From: Carol Reynolds
Sent: 04 December 2018 13:33
To: Anita Gardner
Subject: Re: FG/171/18/DOC - Honda Garage Premises, Littlehampton Road,

Environmental Health: Application for discharge of conditions. Further information required.

Honda Worthing 11-07-18 EXT REV 0

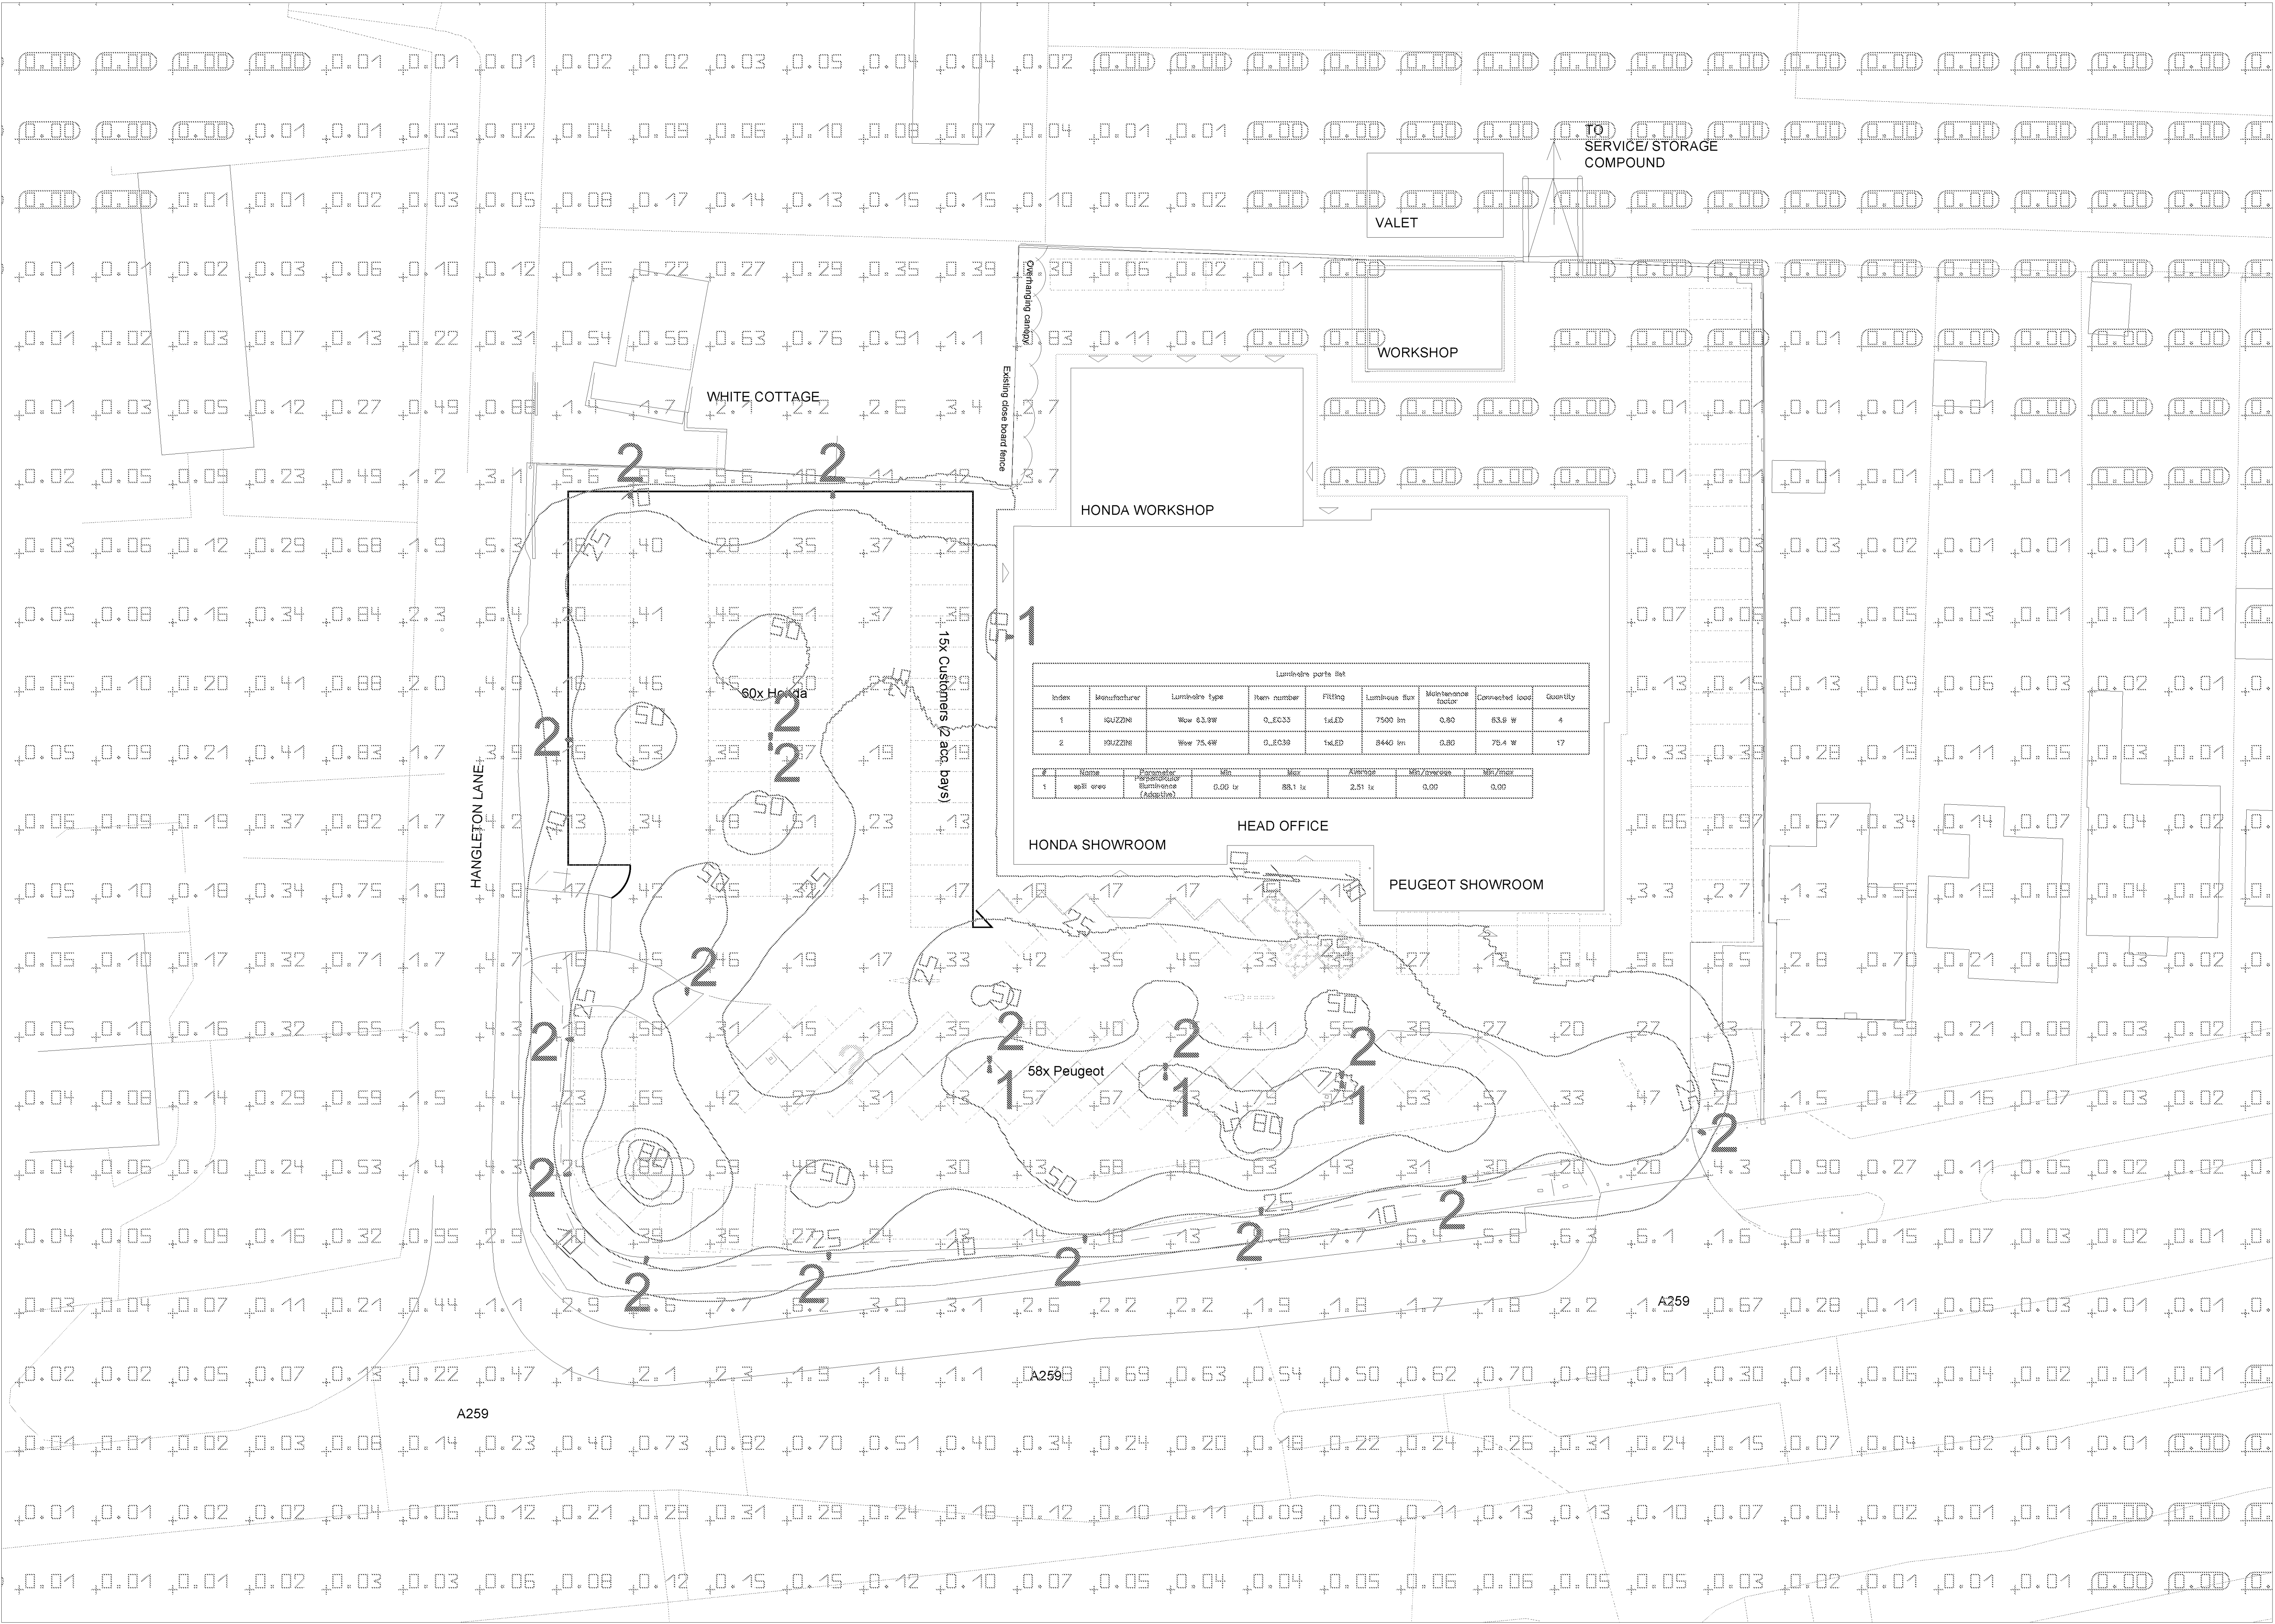
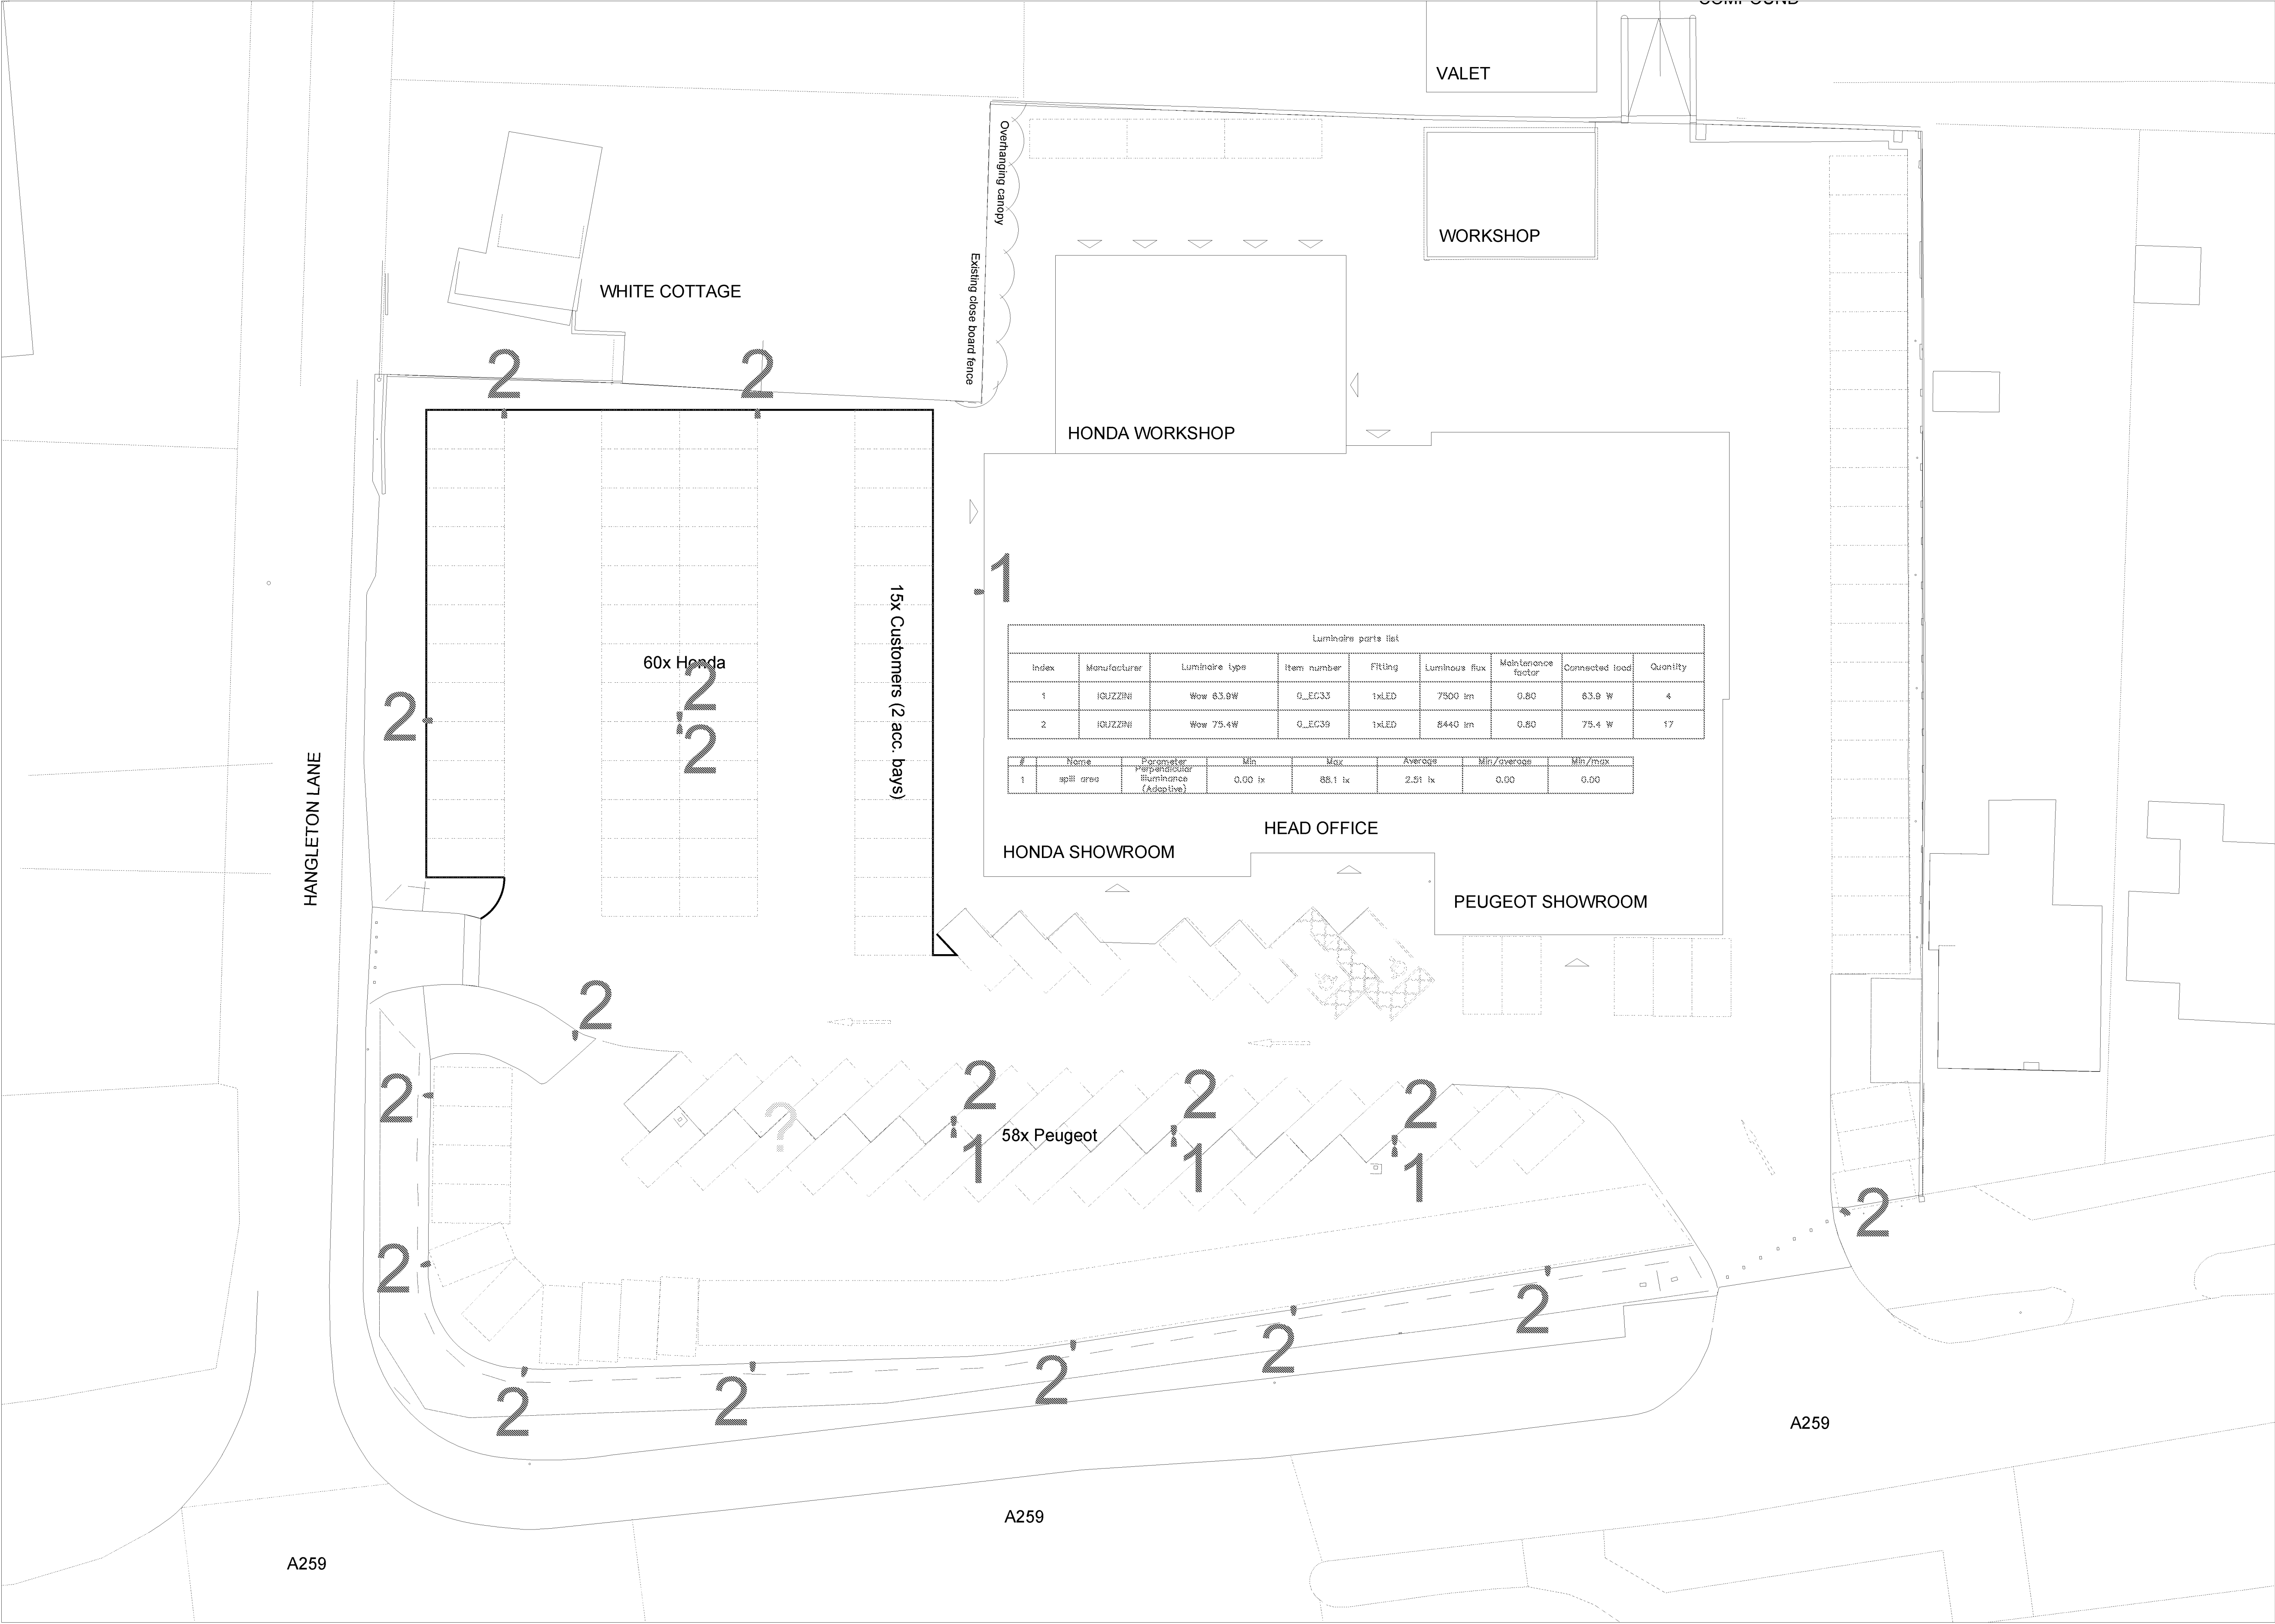
Lighting Plan: Lower level lighting, specified as 'Type 1' to be provided to areas proximal to sensitive receptors and to the north of the site in order to prevent detriment to the amenity of these properties and South Downs National Park.
